KIRKLEES METROPOLITAN COUNCIL INVESTMENT & REGENERATION SERVICE

DELEGATED DECISION TO DETERMINE PLANNING APPLICATIONS

Reference No:	2024/62/90293/W
Site Address:	2, Bank End Knoll, Oakes Lane, Brockholes, Holmfirth, HD9 7BF
Description:	Conversion of garages to living space, internal alterations, installation of gate and replacement windows and doors
Recommending Officer:	Tom Hunt

Officer Report

General Arrangement as Proposed

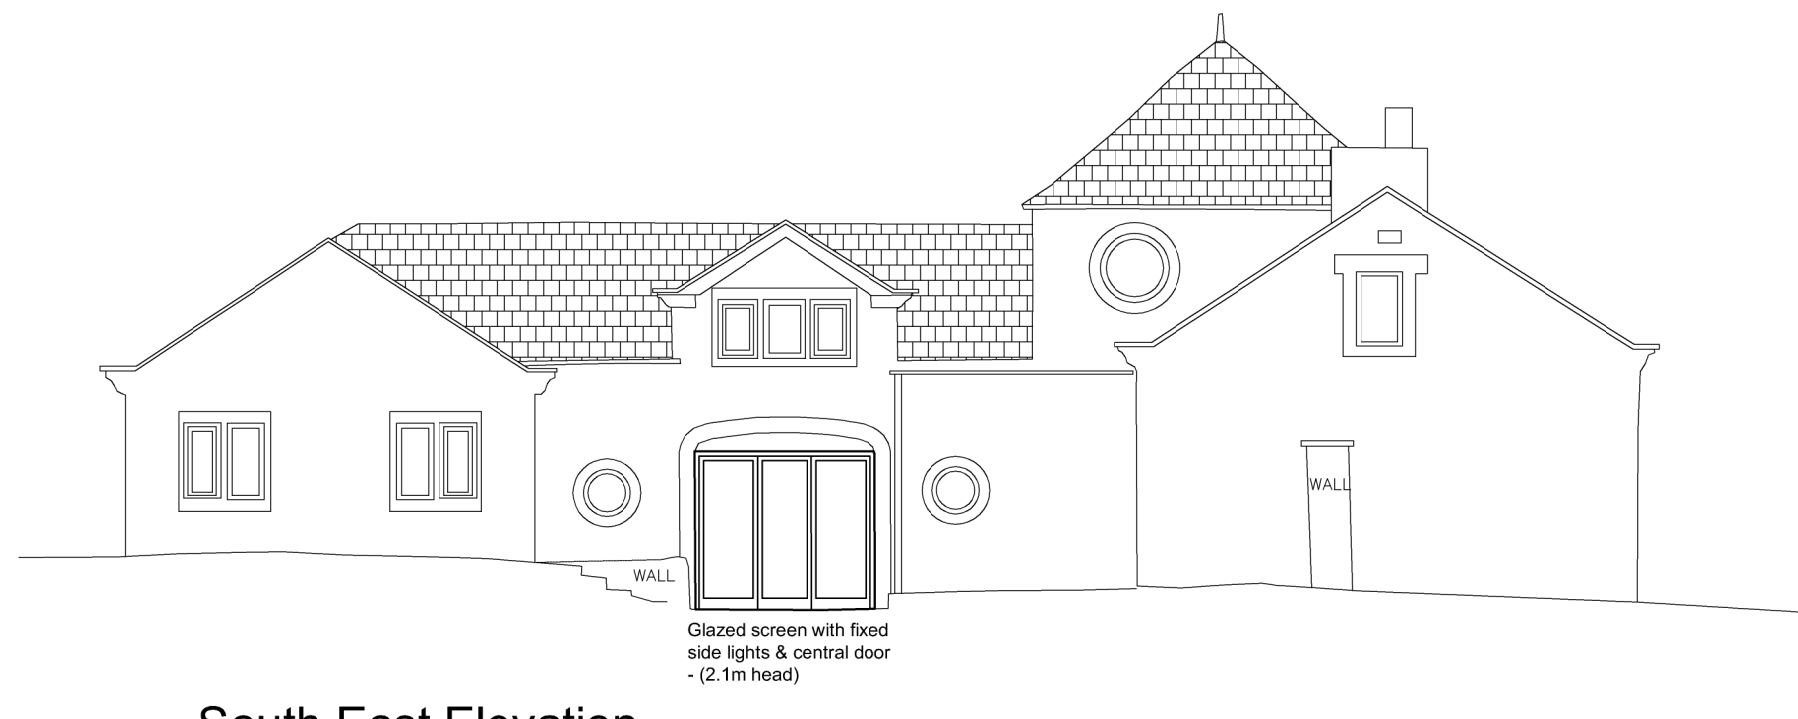
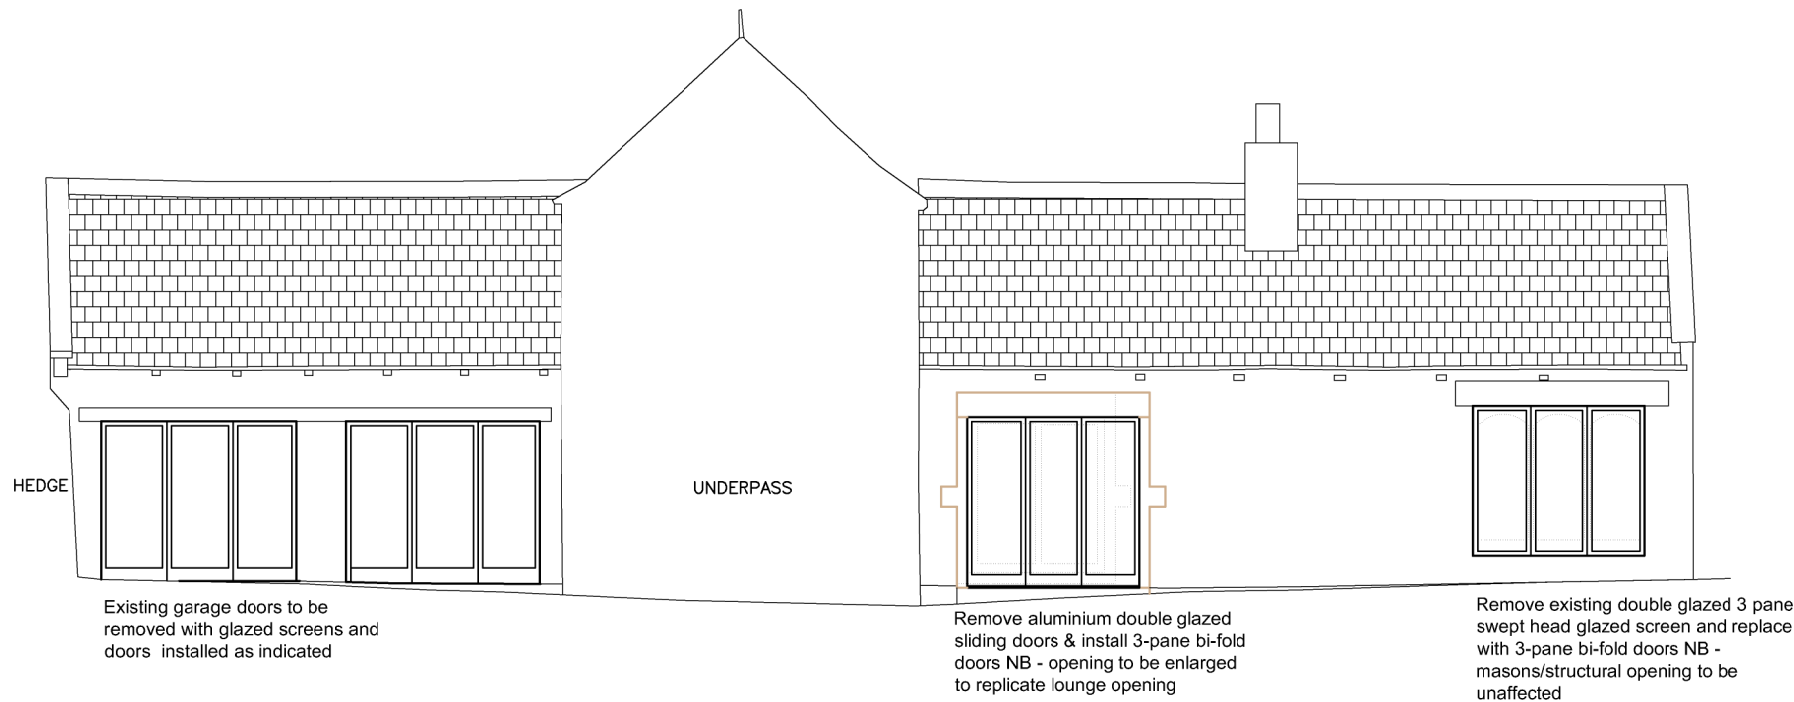
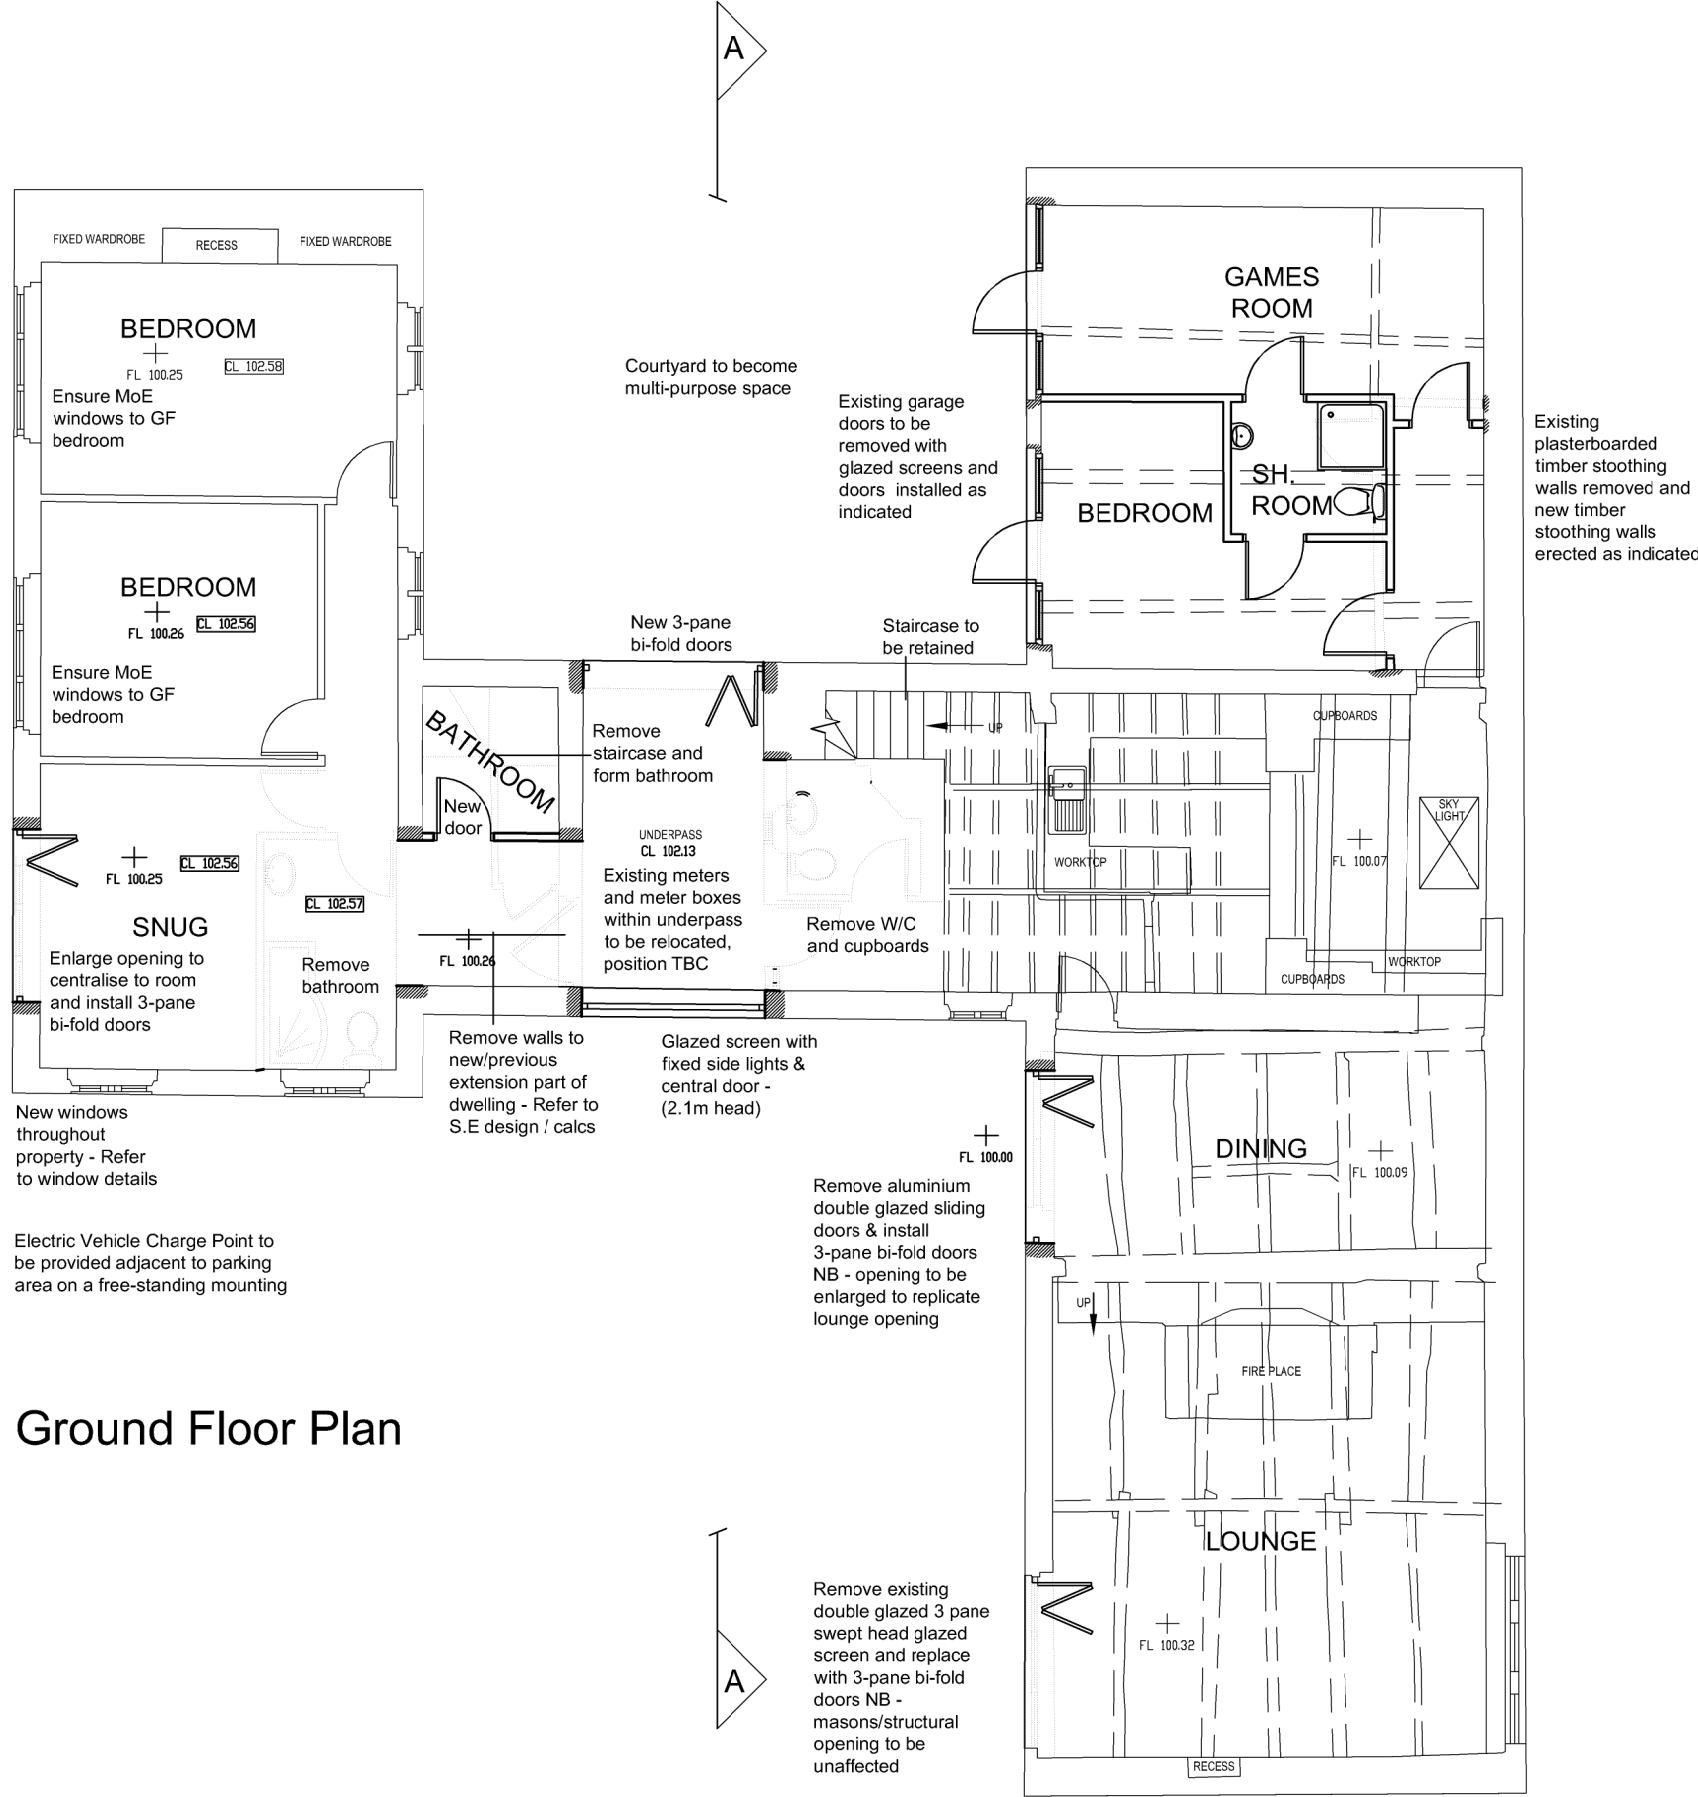
The case officer considered the application on review and sought no amendments as it met LP policies on visual and residential amenity. The Officer requested new windows and doors to be provided in drawings to assess the impact to the Listed Building. The agent requested this to be conditioned to be discharged at a later date.

The proposal seeks to replace and modestly alter existing openings. The east wing is historic and presently has similarly proportioned glazing without mullions. The west wing is non-historic and has a traditionally designed opening to be altered to be made larger. The proposal would have its central wing infilled with glazing. The garage doors would be changed to glazed openings.

3. Notwithstanding the submitted plans, before development commences, the proposed ironmongery details and the joinery details for the replacement windows and doors at a scale of 1:10 showing the profile and section detail at 1:5 shall be submitted to and approved in writing by the Local Planning Authority. The use of friction or egress hinges or trickle vents is not accepted. The windows shall be slim-line double-glazed, limited to 16mm maximum (at 4:8:4 ratio) with black spacer bars and be in timber. Any paint finish submitted

4. Notwithstanding the details provided, the external stone surrounds for the new bifold openings for the dining room and the snug on the west elevations hereby approved shall be of natural ashlar stone and shall replicate the stonework of the existing host window surrounds in terms of stone type, colour, bedding and tooling, albeit with a deep enough section suitable for the span. The surrounds shall be finished in hand tooled stone to match the existing walling, and no power tool cuts or marks shall remain visible. The window stone surrounds approved by this condition shall be retained thereafter.

Proposed Block Plan

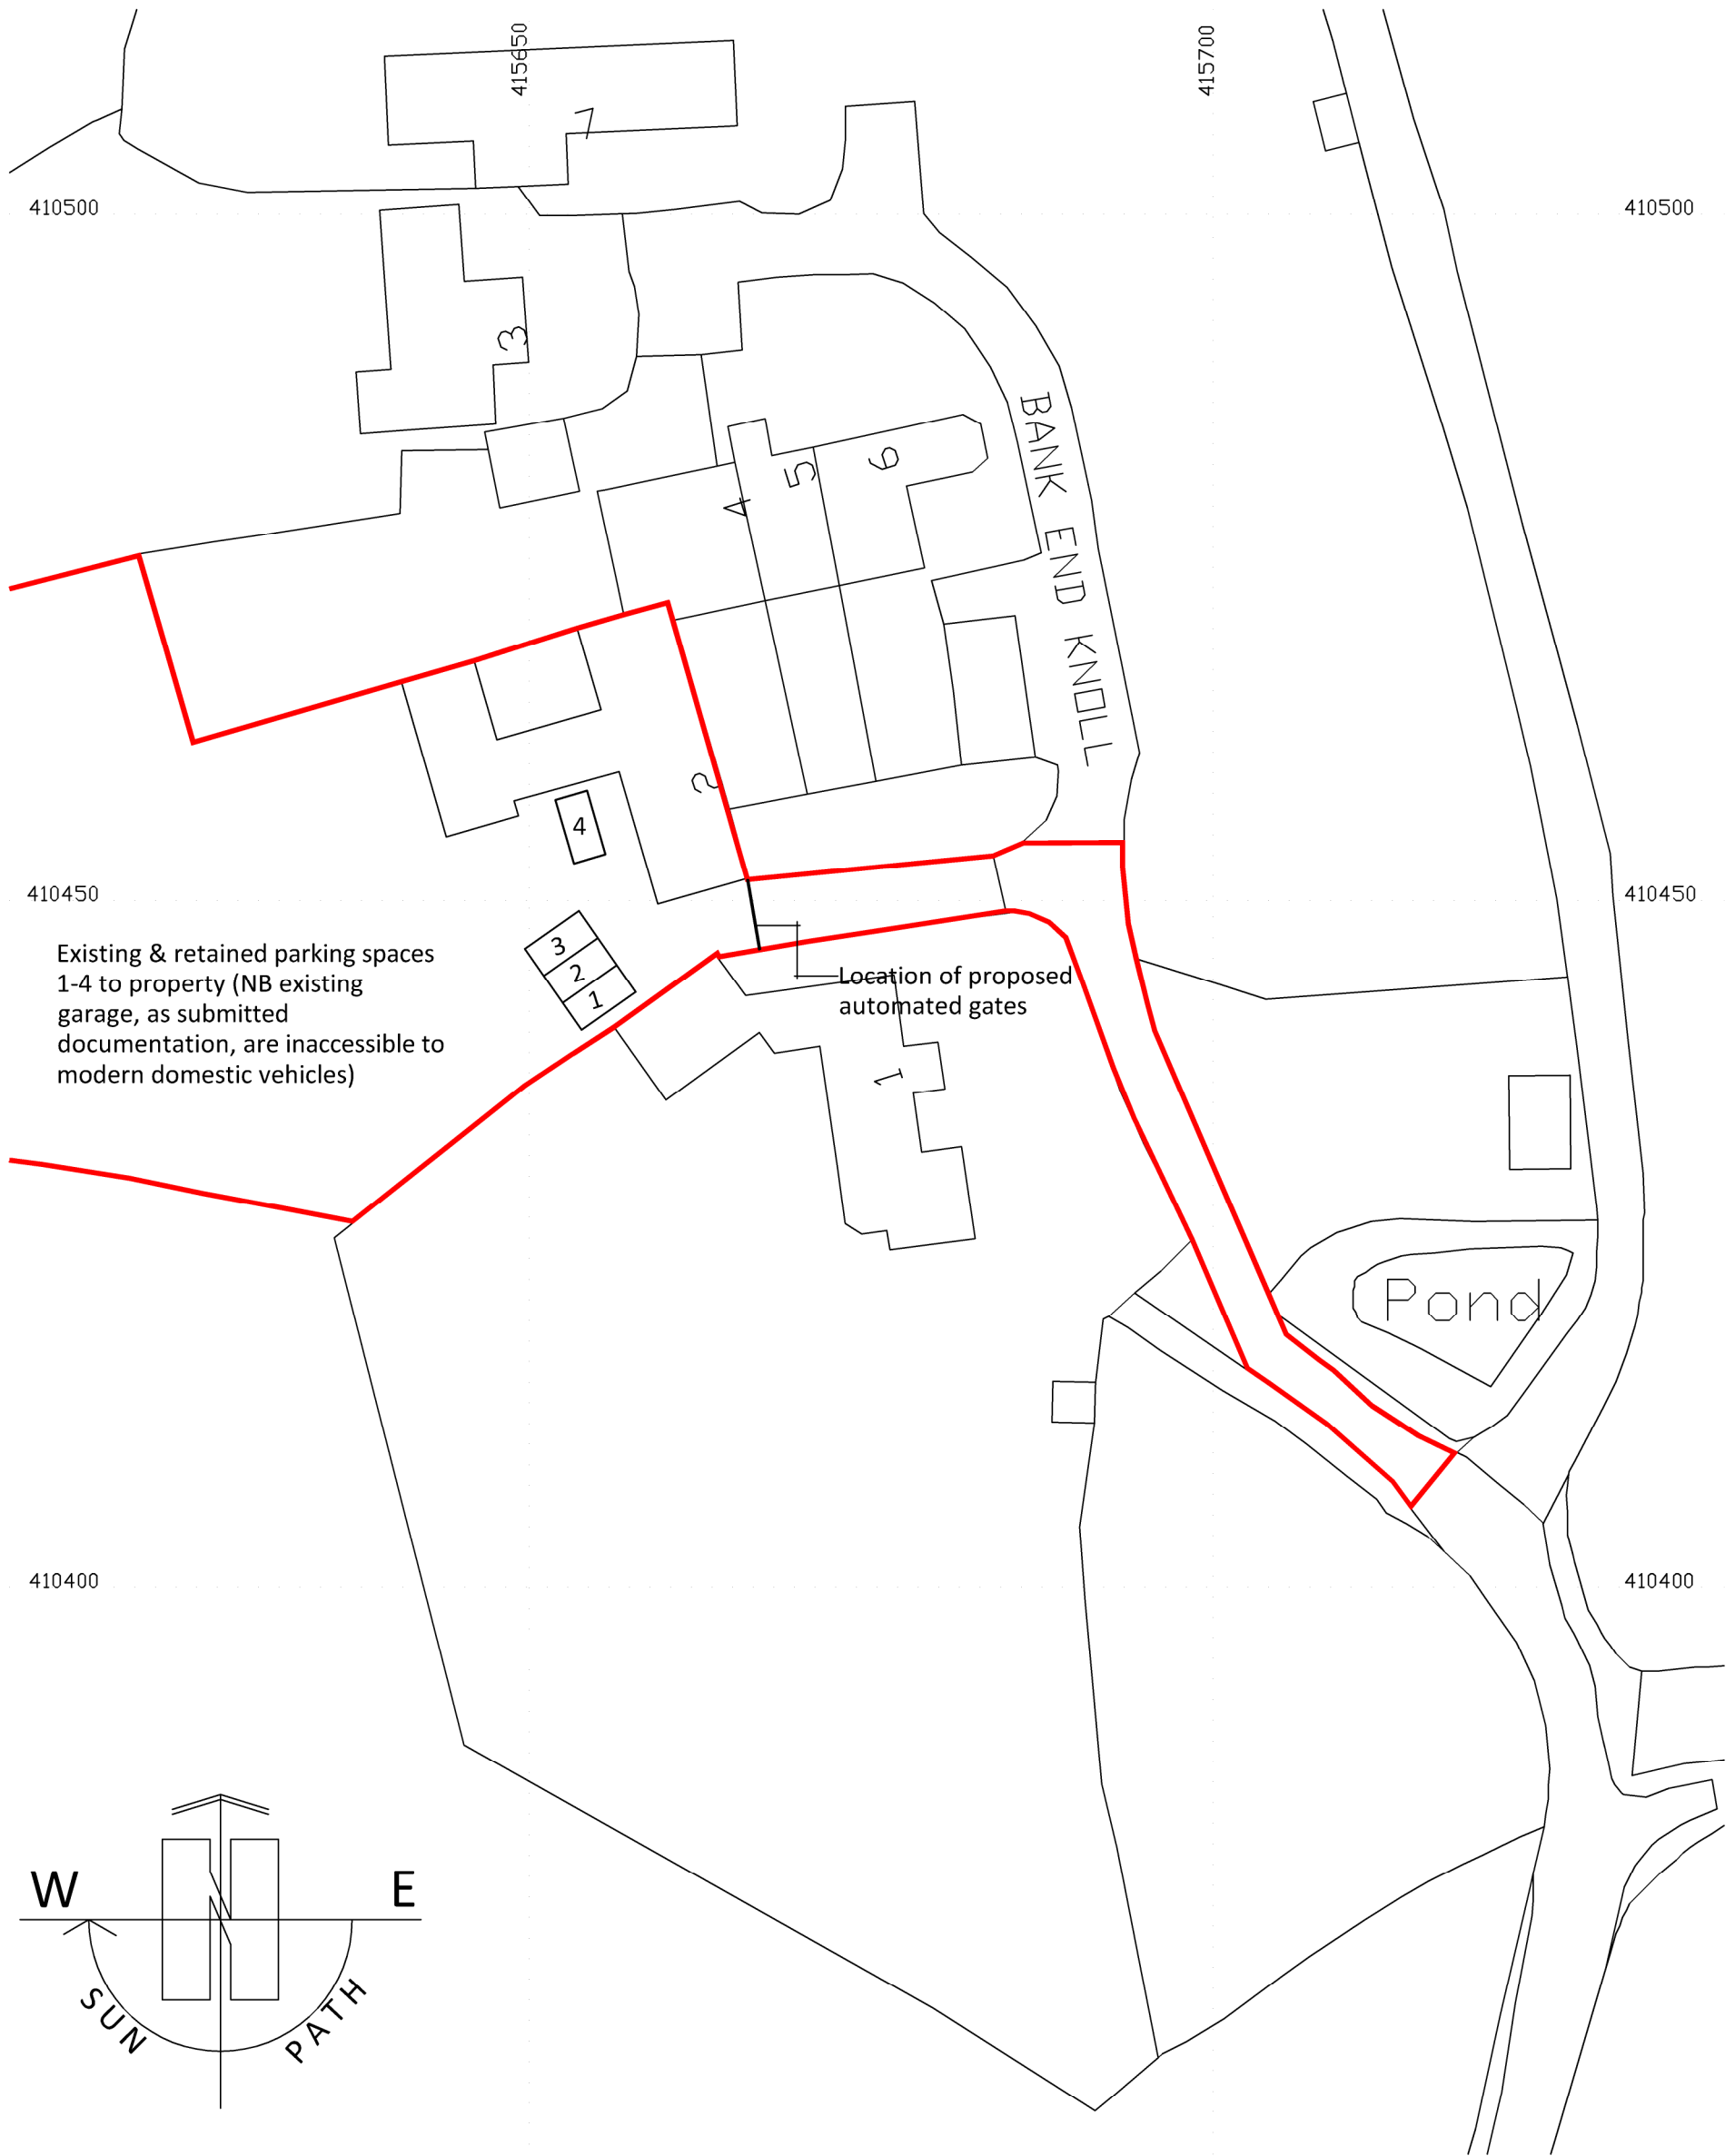
The proposed parking spaces is currently within an existing area serving as parking space. This would have a neutral impact on the Green Belt.

For a 4 plus bedroom dwelling, it should have three off street parking spaces to achieve this aim. The proposal would remove two garaging spaces which are inaccessible to modern vehicles and do not meet Highways Design Guide SPD standards for internal garaging spaces. The use of existing hardstanding for parking four vehicles would have a neutral impact on parking. Bin arrangements have not been set out however the substantial plot size would adequately allow bins to be stored practically without detriment to the highway.

5. Prior to the conversion of the garage into living quarters, one electric recharging point shall be installed within the dedicated parking area of the dwelling hereby approved. Cable and circuitry ratings shall be of adequate size to ensure a minimum continuous current demand of 16 Amps and a maximum demand of 50Amps. The electric vehicle charging point so installed shall thereafter be retained.
